Comments in relation to the application for quarrying at Bromley farm from

The Cumberworth Quarry Action group .

Application number 2023/91280

Figure B1: HDVs Haulage Route**Figure B2: Spatial modelling scope including verification site and the receptors**

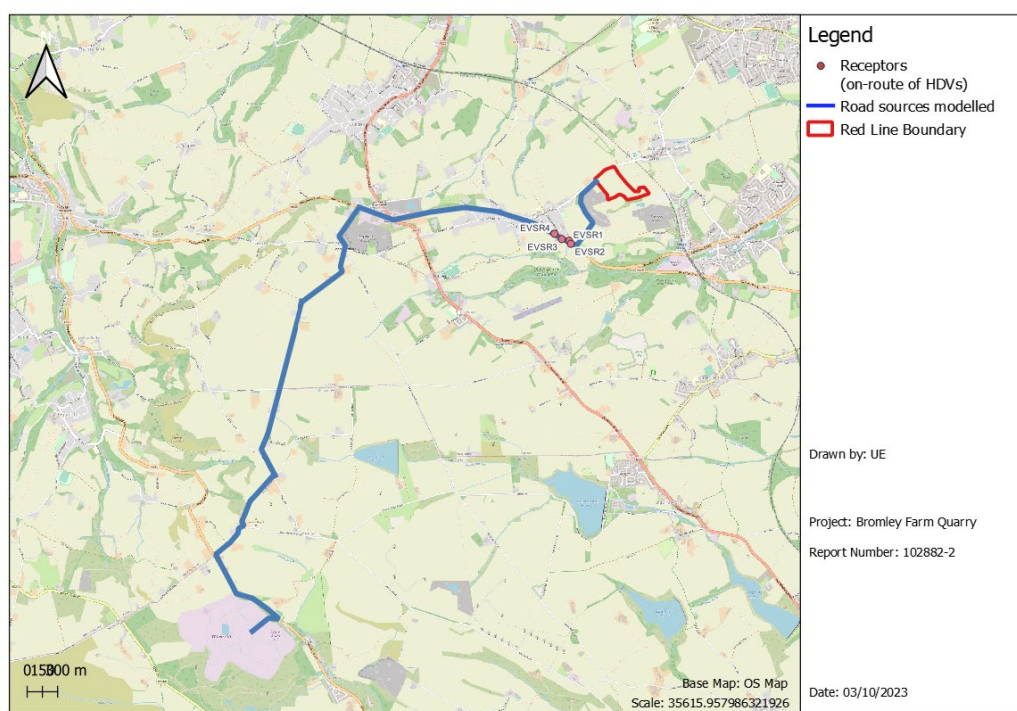
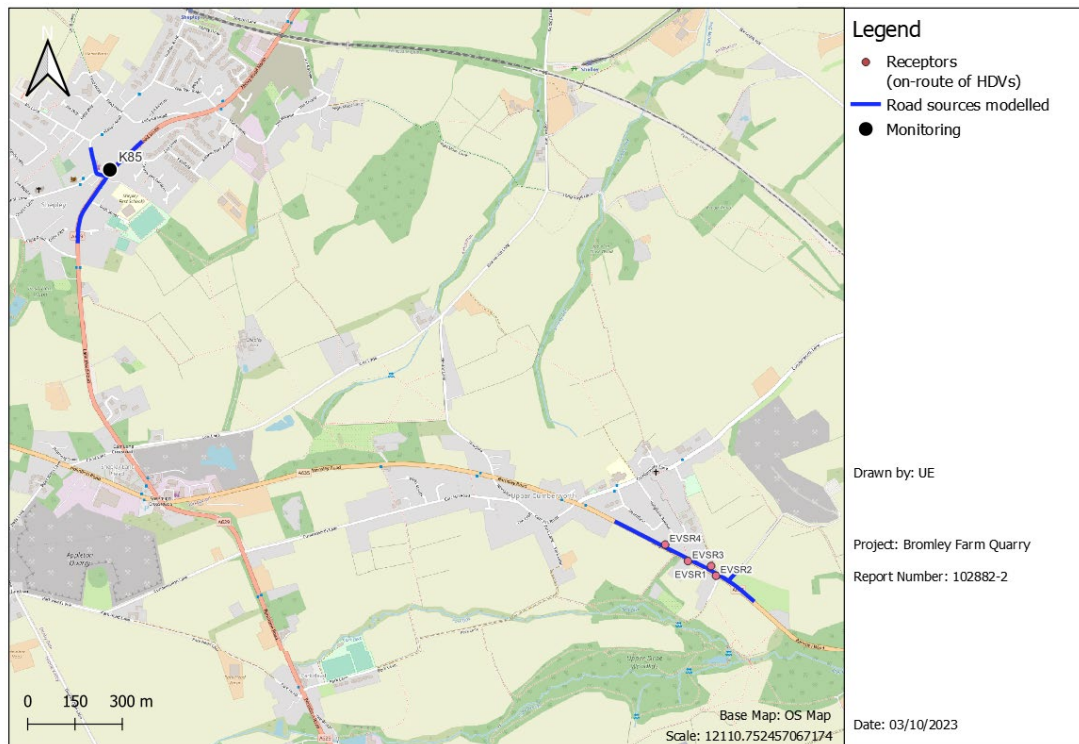
4. We note the proposed new route but would point out there has been no consultation either prior or during the latest round of paperwork with those along the route. All of whom will be impacted if this development proceeds.

1. While pleased that the highways team from Kirklees , have indicated that they will not support an application for the use of rural roads and acknowledge the request for additional modelling. The re routing of HGVs from Carr Hill Road is welcomed , although it begs the question if not suitable for these vehicles why is it suitable for any HGV a matter we will pick up separately.

16. Where is the evidence in relation to noise and pollution , the number of lorries trundling along Barnsley Road , laden with material for the site is going to impact significantly on the noise and dust experienced by those houses backing onto or facing Barnsley road.

17. In short there is no impact analysis or risk appraisal of laden waggons (of whatever type) , with a 44 tonne payload , using the now proffered route , which is already busy , is a frequent accidents site – and includes making a descent into backing up and queuing traffic. A decision made in the absence of appropriate risk appraisals by Kirklees Planning to allow this to proceed would be reckless and unreasonable.
